Planning Application Decision Notice

REFUSAL OF PERMISSION FOR DEVELOPMENT

Application Number: 2024/62/90389/W

**ERECTION OF STAIRCASE TO FRONT ELEVATION WITH REPLACEMENT
PORCH ROOF AND ALTERATIONS (RETROSPECTIVE)**

Retrospective Proposed Front Elevation
1 : 50

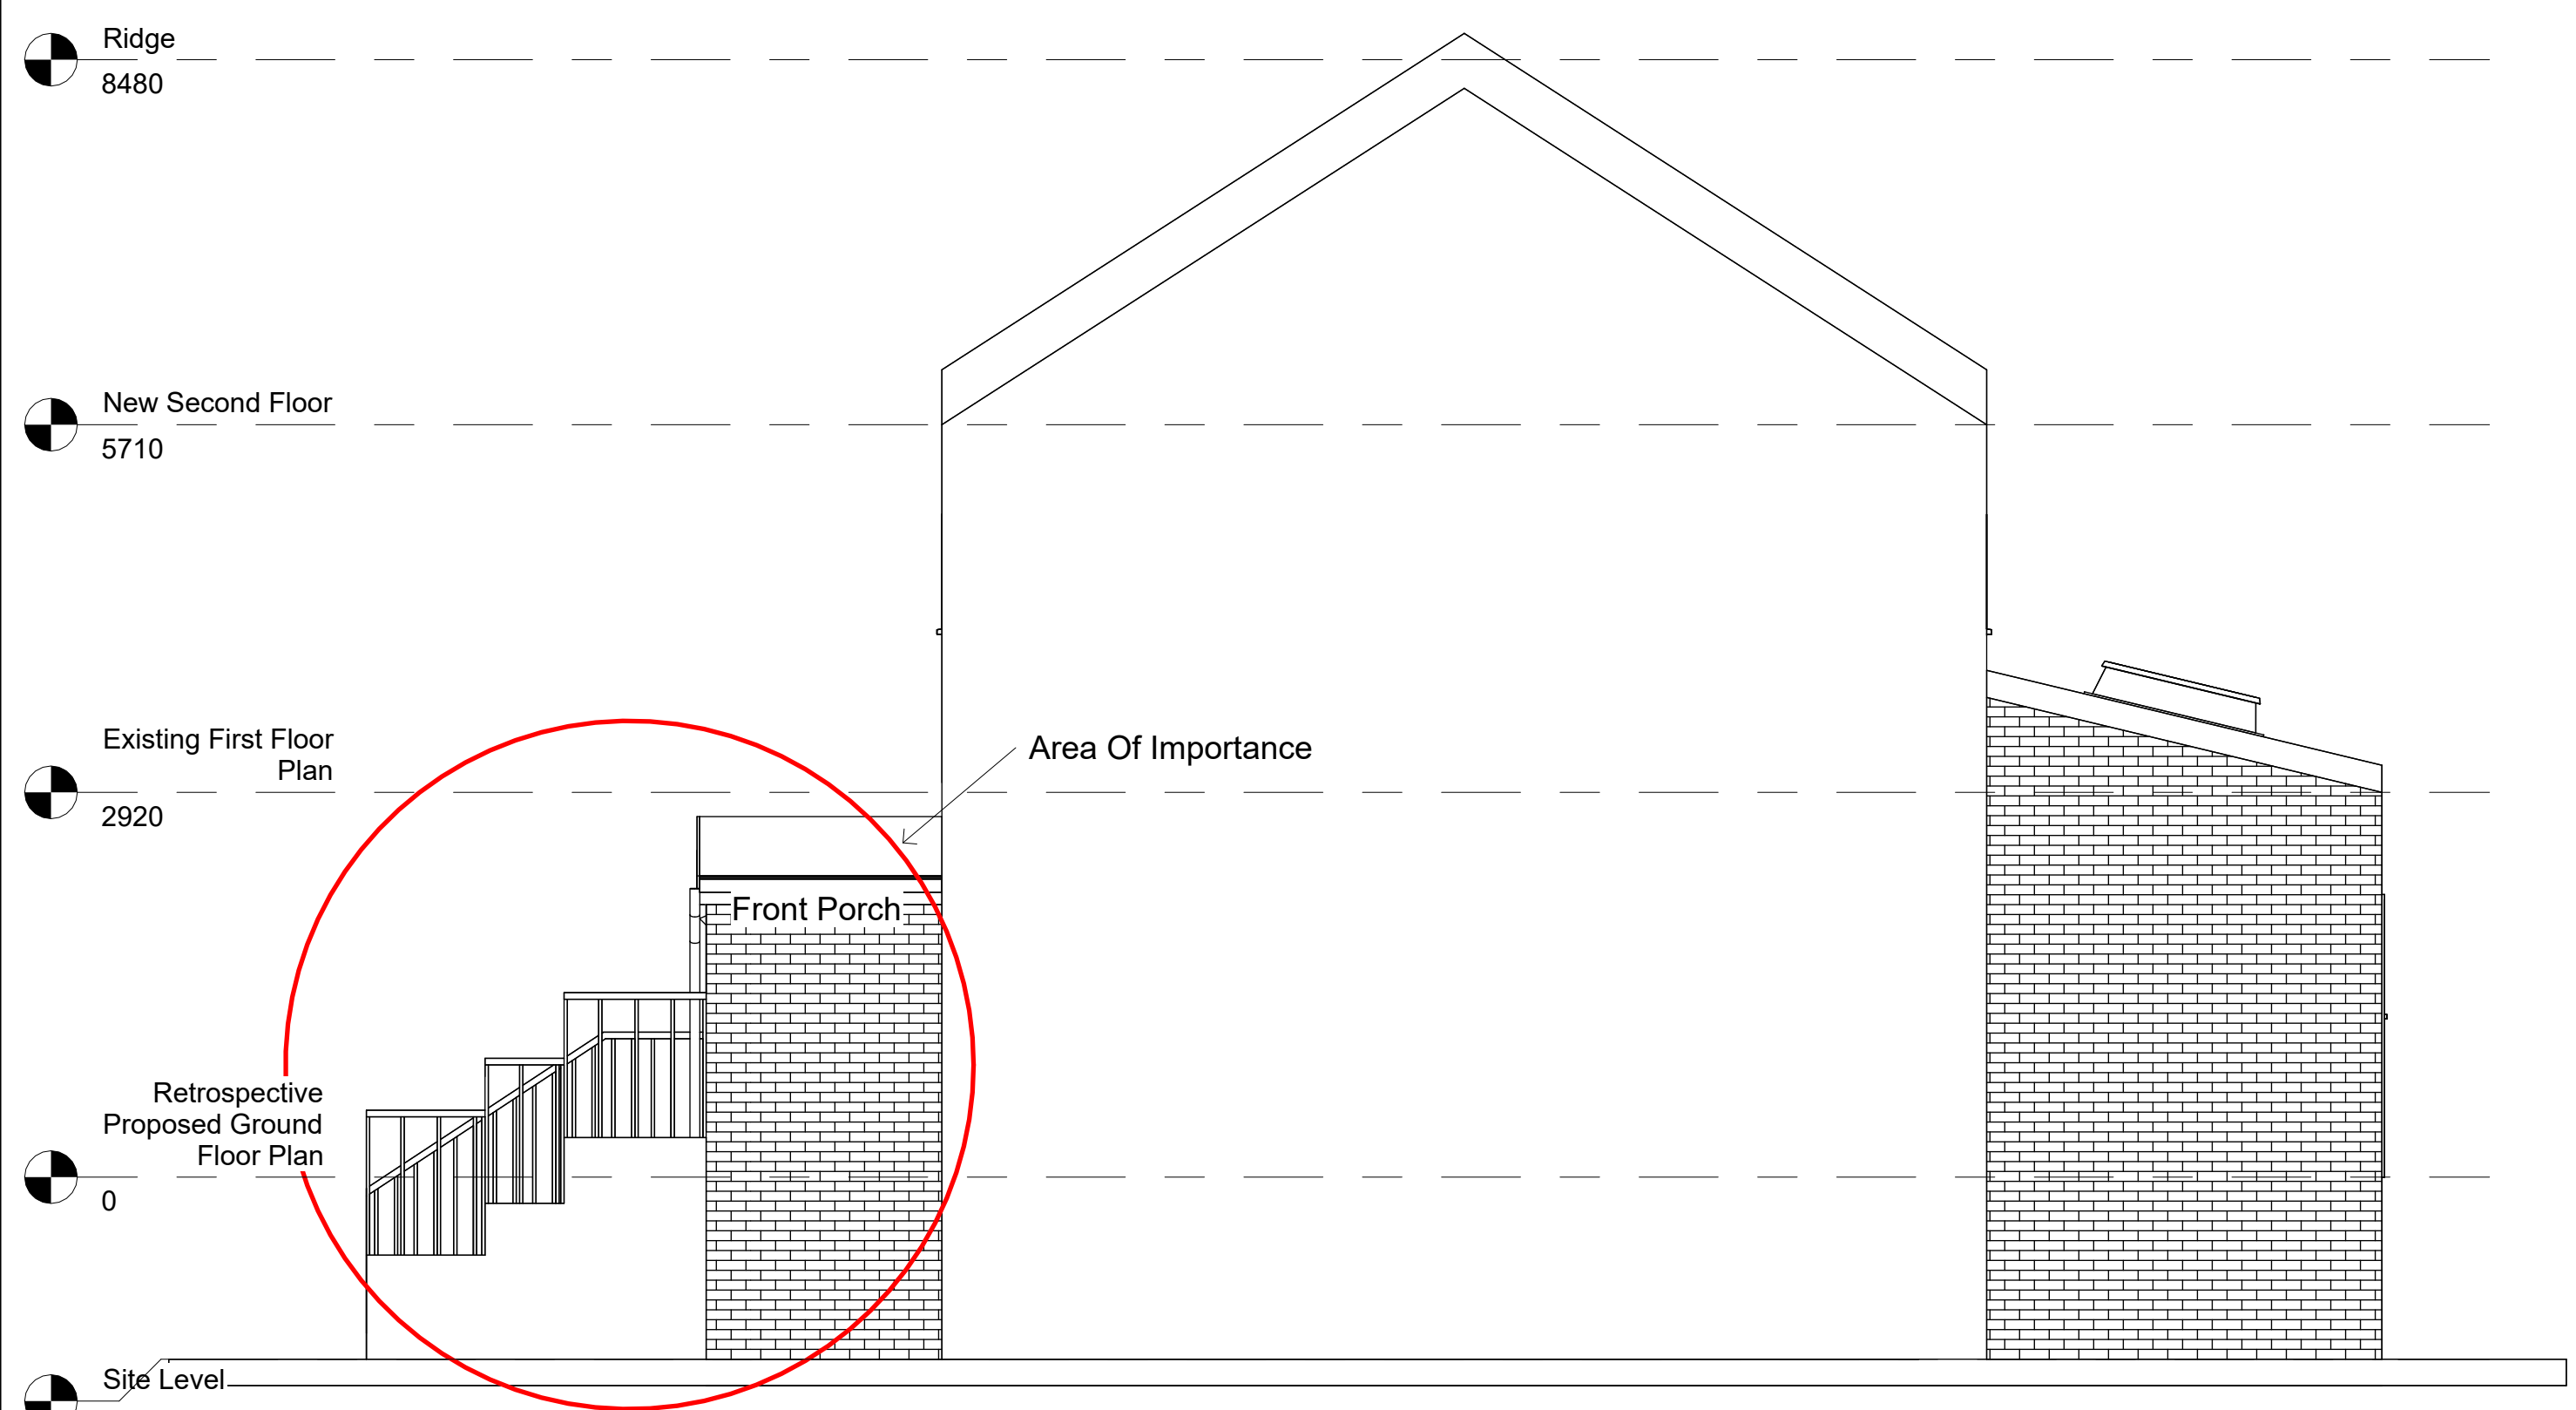
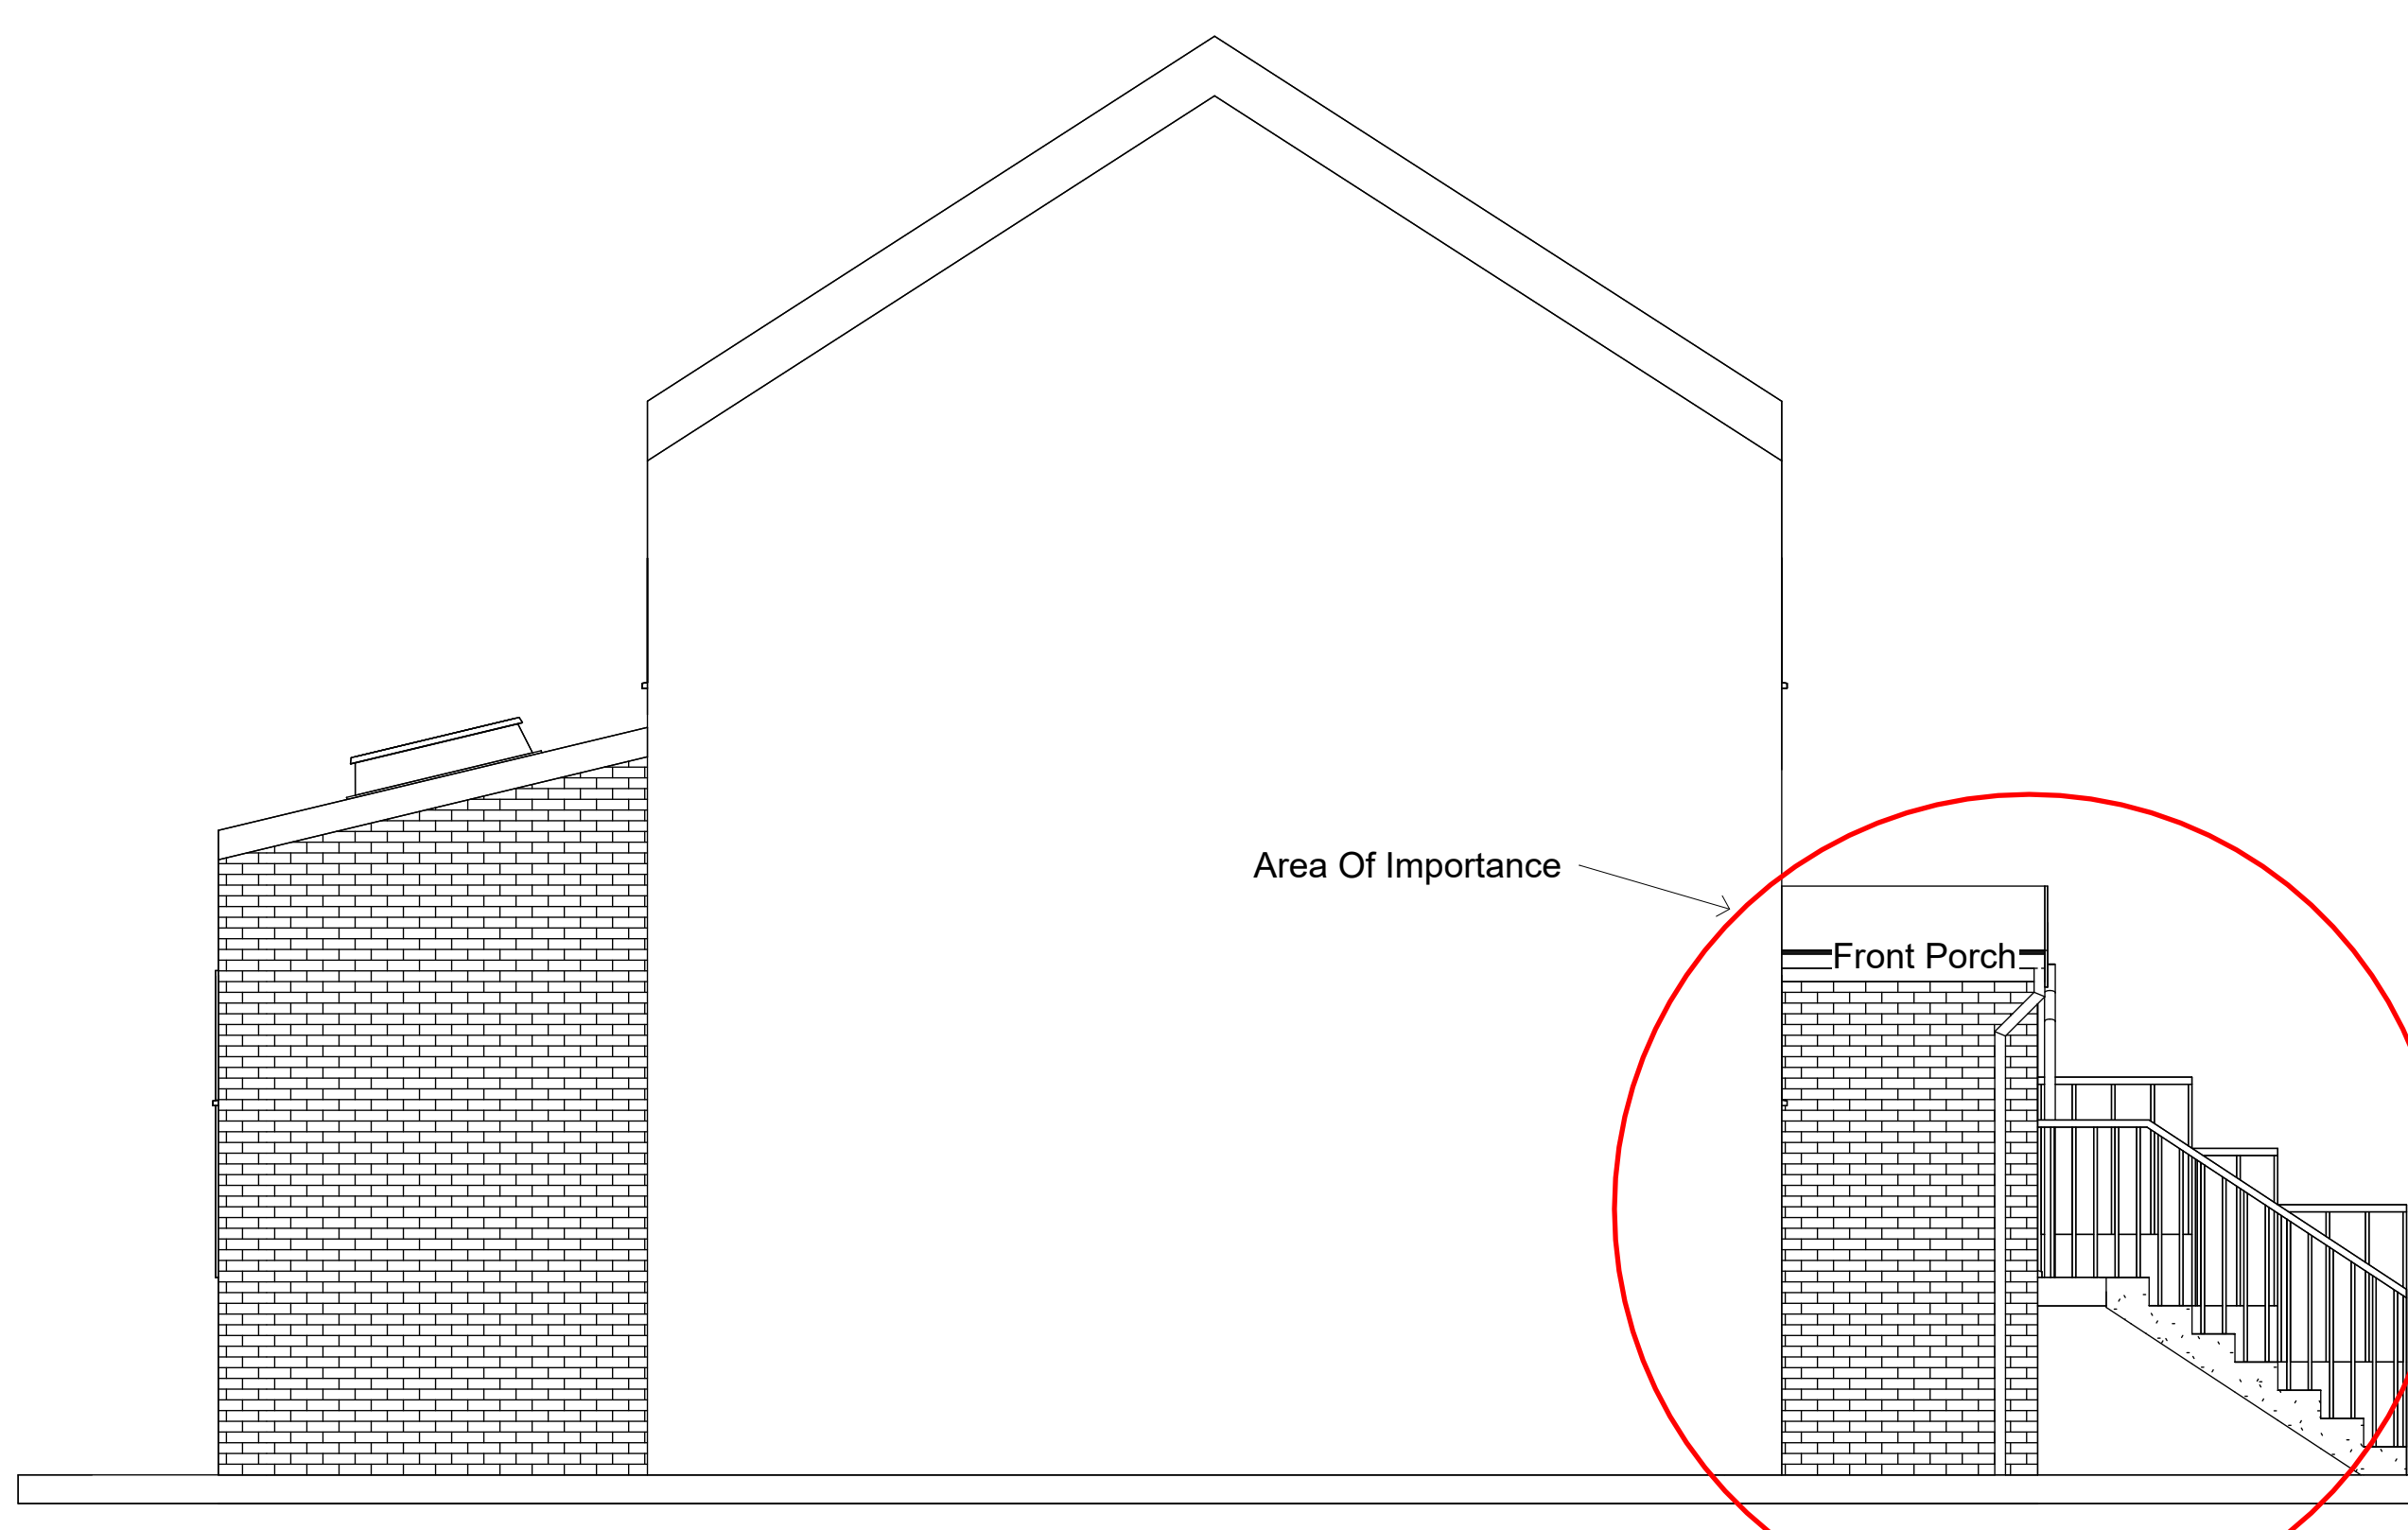
1. The proposed development, due to the prominence and depth of the staircase, in conjunction with the pitched roof of the porch and associated works in totality would detract from the visual amenity of the area and form an overly prominent and incongruous feature which has an adverse visual impact, and which fails to harmonise with the host building and wider terraced row. This would not comply with Policy LP 24 (a and c) of the Kirklees Local Plan, Key Design Principles 1 and 2 of the House Extensions and Alterations Supplementary Planning Document and advice within Chapter 12 of the National Planning Policy Framework.
